CITY OF ALBUQUERQUE

December 18, 2020

**Re: Top Golf
1600 Desert Surf Circle. NE
30-Day Temporary Certificate of Occupancy
Transportation Development Final Inspection
Engineer's/Architect's Stamp dated 9-16-19 (AA) (F16D003E1)
Certification dated 12-11-20**

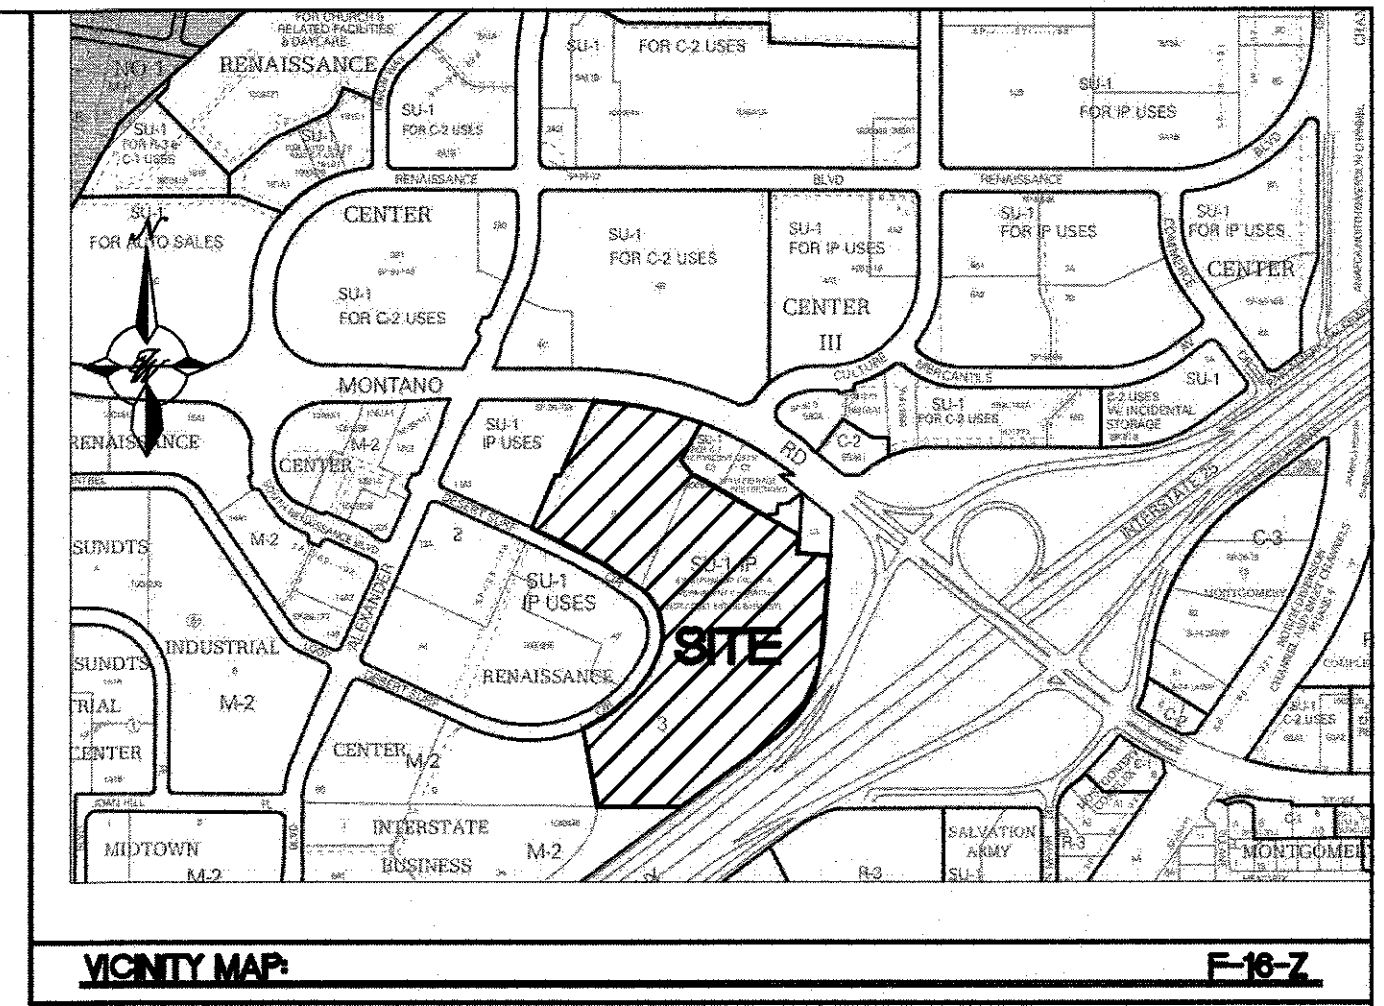
- The valve collar poured near the front entrance and the materials and driveable glass removed that is blocking the east parking lot access aisle and the pedestrian way in front of the building.
- All project materials removed from the site and the trash dumpster. The project needs to be swept up and leaves need to be removed at the handicapped ramp to the roadway right-of-way.

1. The approved and stamped Administrative Amendment with changes drawn in red.
2. Transportation Certification letter on either the plan or applicants letterhead.
3. A Drainage Transportation Information Sheet (DTIS)
4. Send an electronic copy of your submittal to PLNDRS@cabq.gov.
5. The \$75 re-submittal fee for log in and evaluation by Transportation.
